**Re: Permit #** SHL18-017  
**Project Name** Lakeshores Group Community Dock  
**Project Address** 5067 84<sup>th</sup> Ave SE (parcel # 407600-0080)  
**Reviewer** Andrew Leon, Planner  
**Department** Planning & Development

Below are our responses to your comments from June 17, 2022. Your original comments are in ***bold italics*** followed by our response in plain text.

SITE PLAN
SCALE 1" = 40'-0"

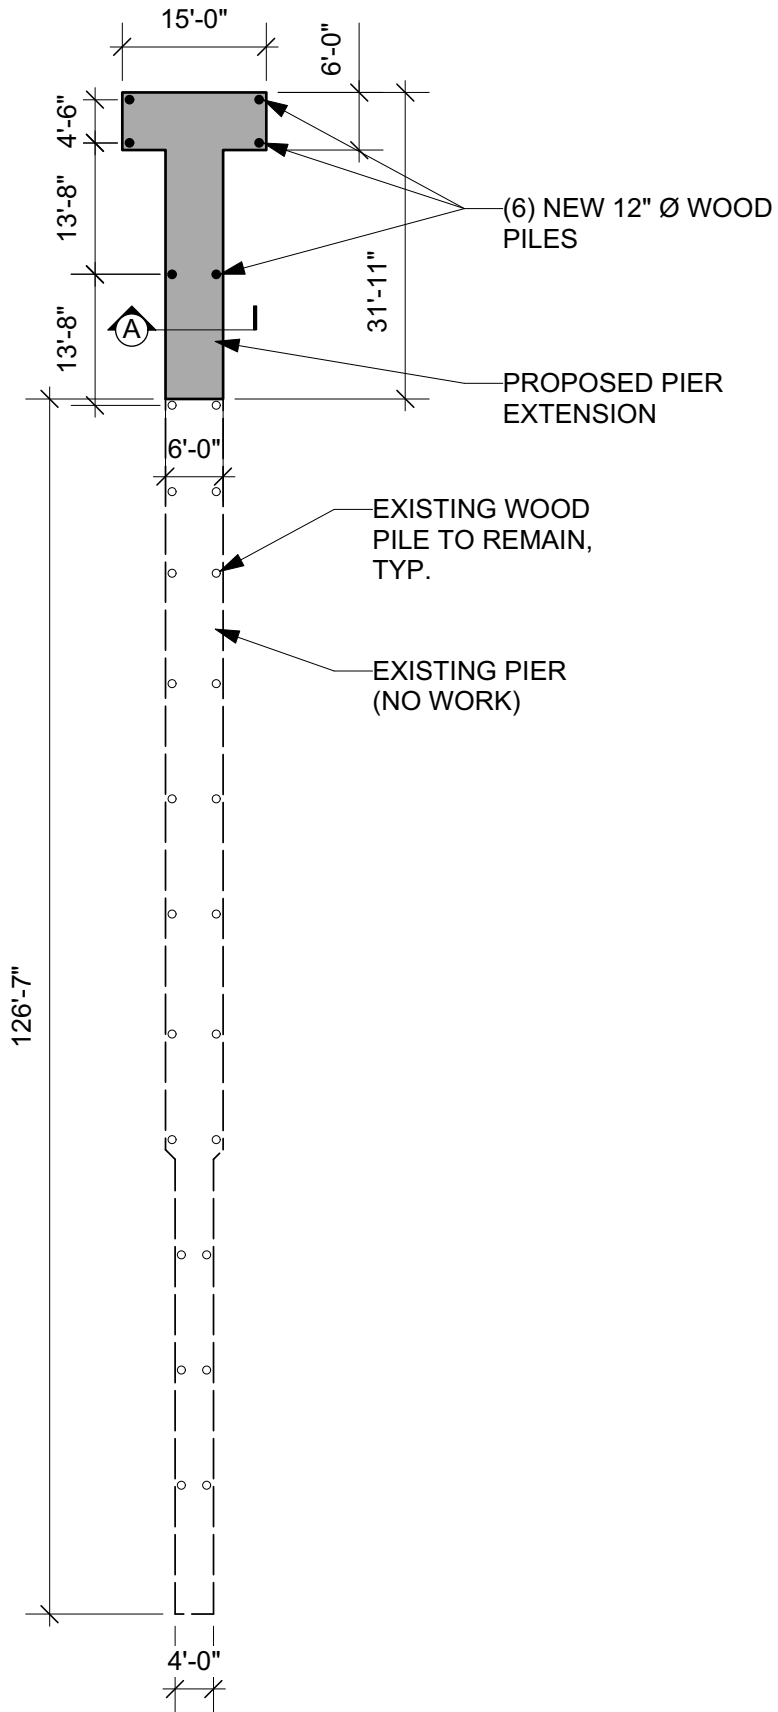
***2. The existing sewer manhole and pipe are not shown as requested.***

Per your July 7, 2022 email there is no sewer manhole at the site. FYI the sewer easement has been shown on the plans per easement recording number 5850953.

PLANTING PLAN

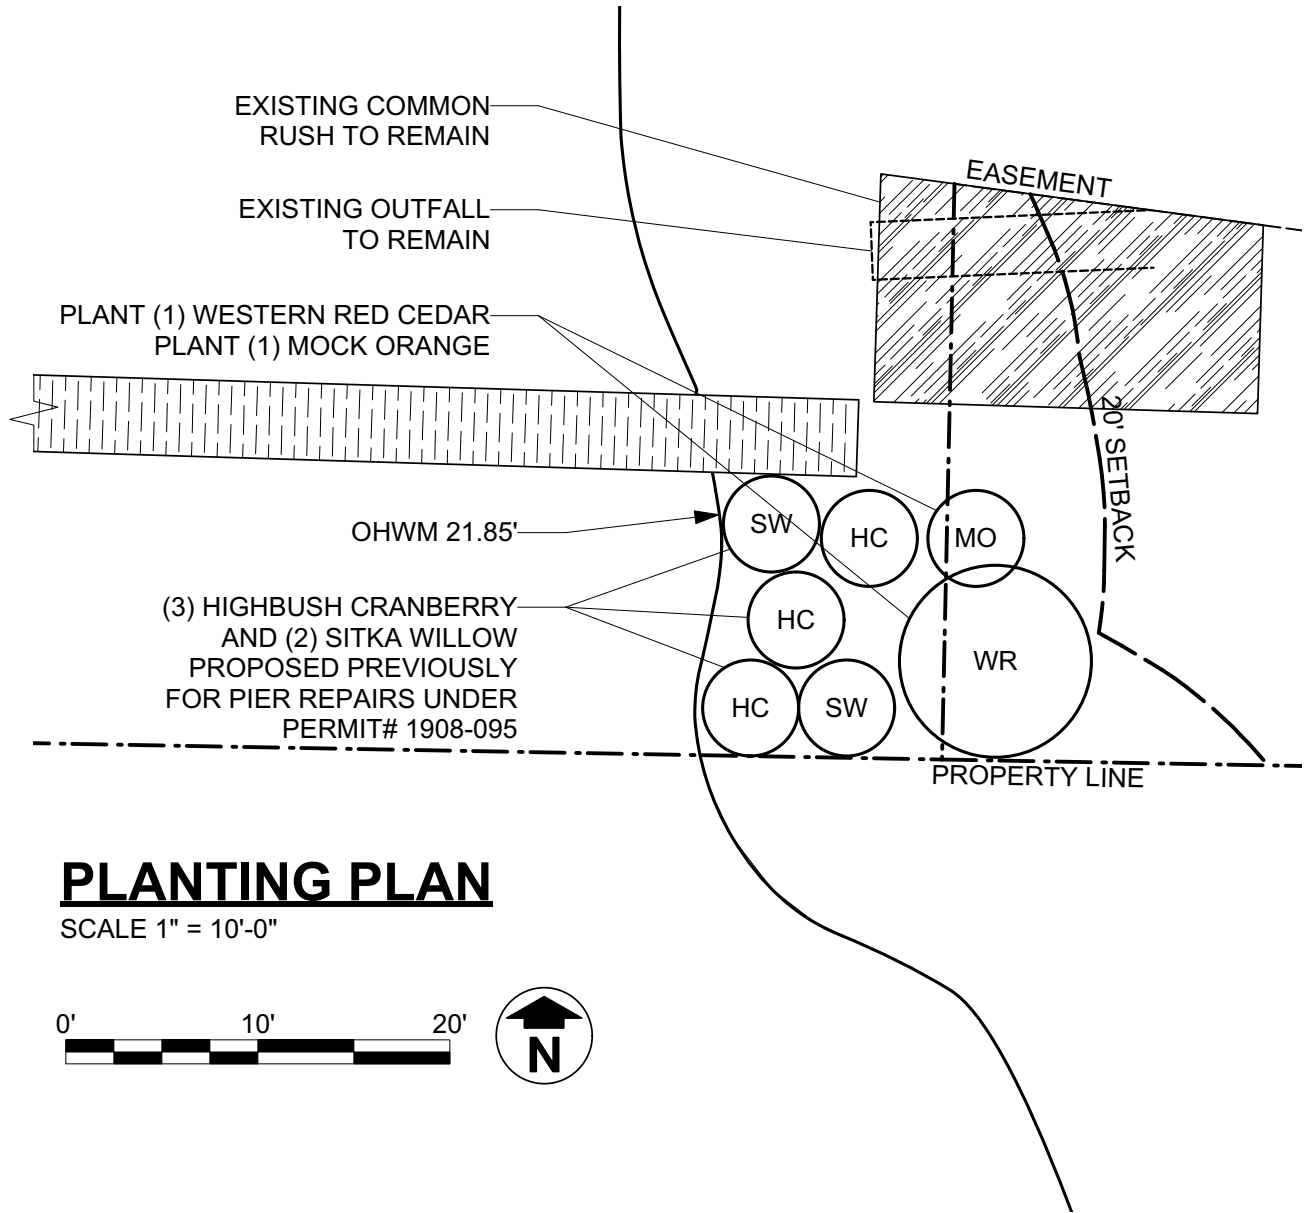
***3. The plantings (HC and SW) must be located outside of the easement.***

The HC and SW plantings inside the easement have been removed from the plans.

**FALLQUIST DOCK SURVEY**  
5061 84TH AVE. SE, MERCER ISLAND, WA  
RICHARD FALLQUIST

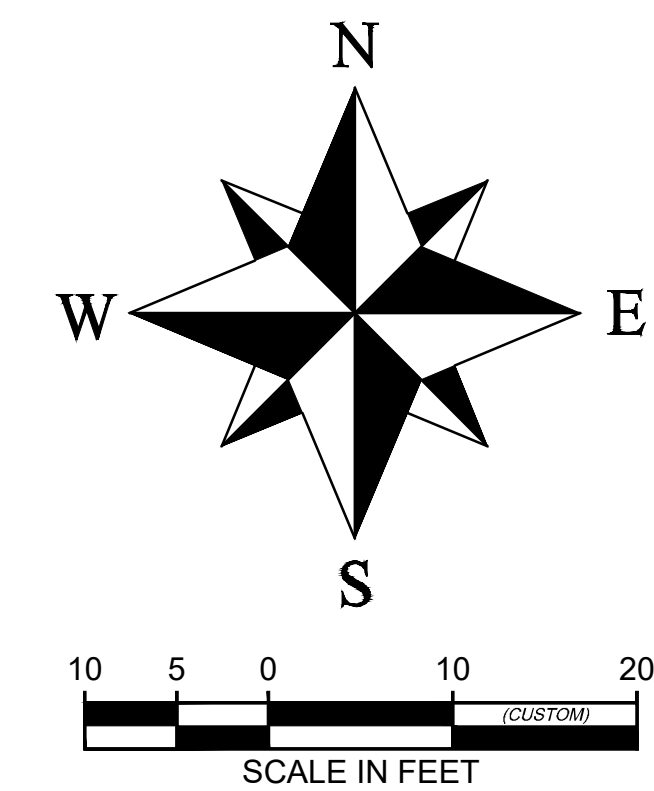
***1. The location of the existing storm easement does not appear to be shown correctly. Please verify the actual location of the storm easement. Also the existing storm pipe does not show as requested.***

The storm easement has been shown per easement recording number 7405140437 which states that it is the 'north 10 feet of the south 31.5 feet of lot 8 Lake Shores...' The storm drain was located by the surveyor and a copy of the survey has been included. The surveyed location of the storm drain is consistent with the easement.
